**REQUEST**

Current Zoning: NC (neighborhood center)  
Proposed Zoning: MUDD-O (mixed use development, optional)

Approximately 0.94 acres located at the southeast intersection of Commonwealth Avenue and The Plaza, north of East Independence Boulevard.

**SUMMARY OF PETITION**

RZ-1

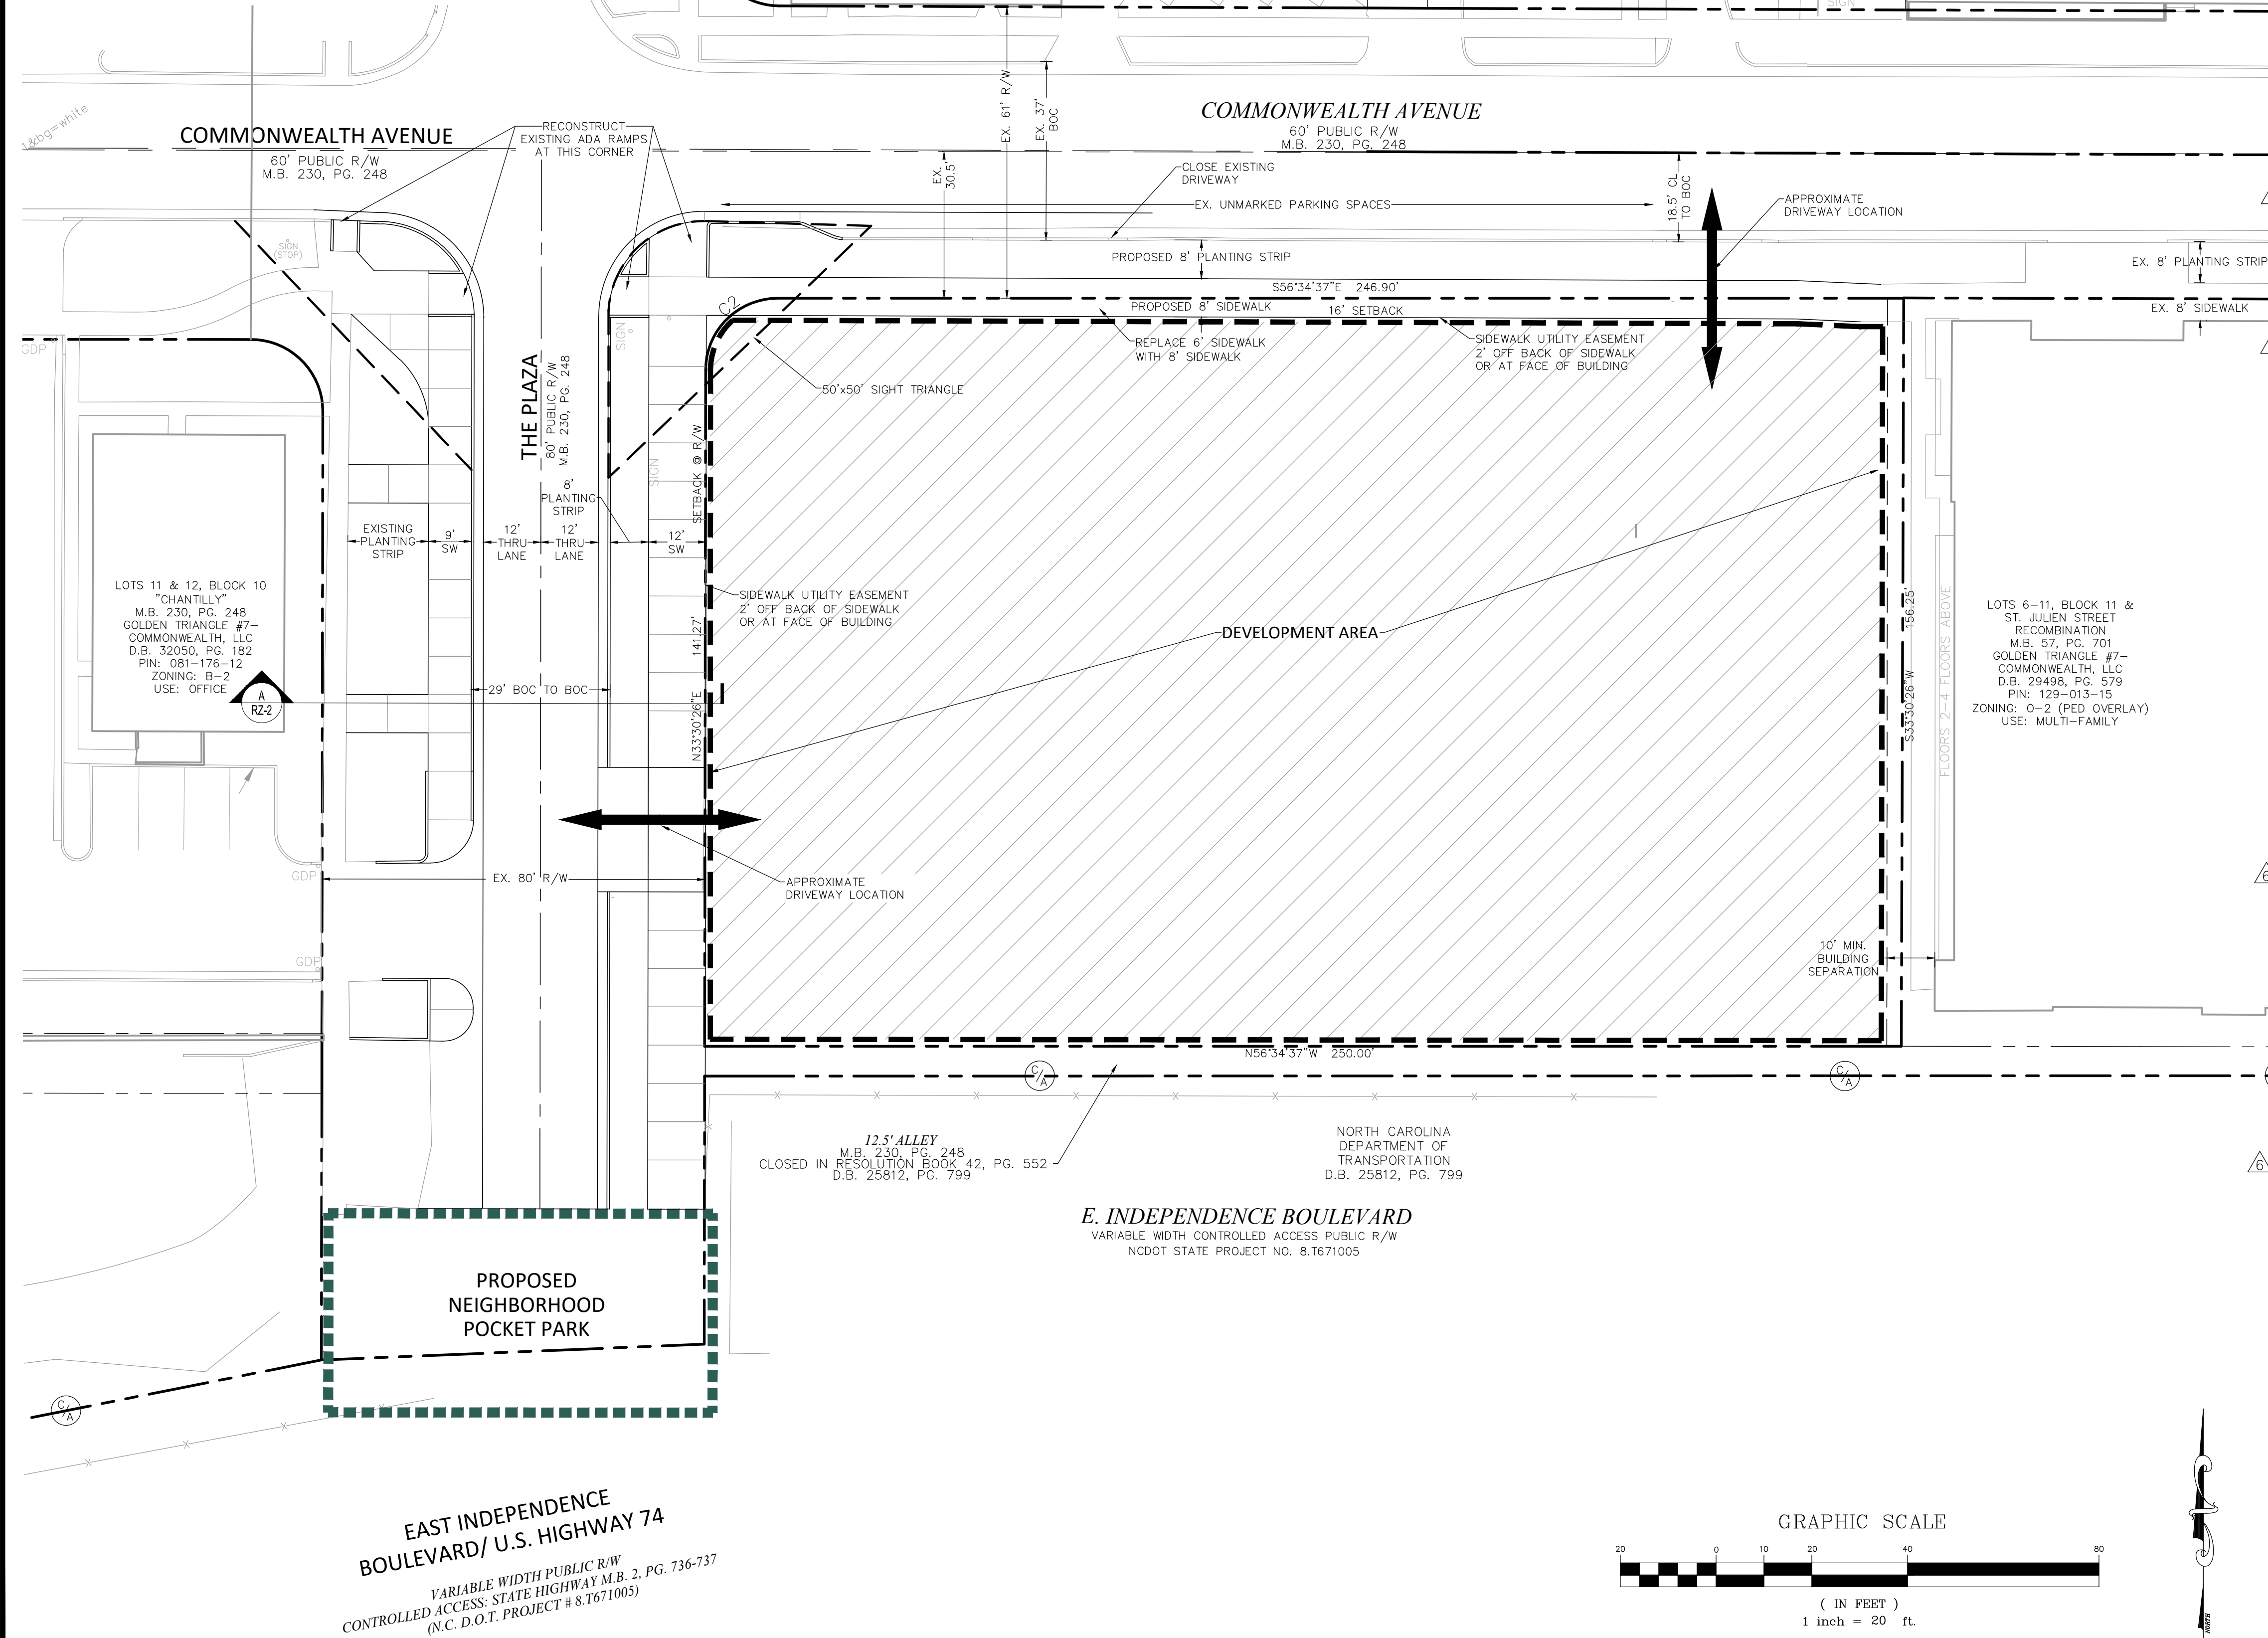
1. Show required right-of-way trees. **Addressed**

2. The back of curb sidewalk shown is not acceptable to CDOT, remove from plan. Based on the context of the street CDOT can consider a consider a local office/commercial wide with parallel parking and curb bumpouts per CLDSM U-05, with amenity zone instead of planting strip. In addition, remove proposed park — park not allowed in right-of-way. **Addressed**

4. Reduce the maximum height to provide contextual sensitivity to the surrounding building forms. **Addressed**

5. ~~Revise note 7 under the Design Guidelines to commit to community benefits to achieve building height above 80'. Commit to specific community benefits.~~ **Addressed**
  6. ~~Identify building envelopes(s) rather than one development area.~~ **Rescinded**
  7. ~~Remove optional provision allowing for a drive-through.~~ **Rescinded**
-
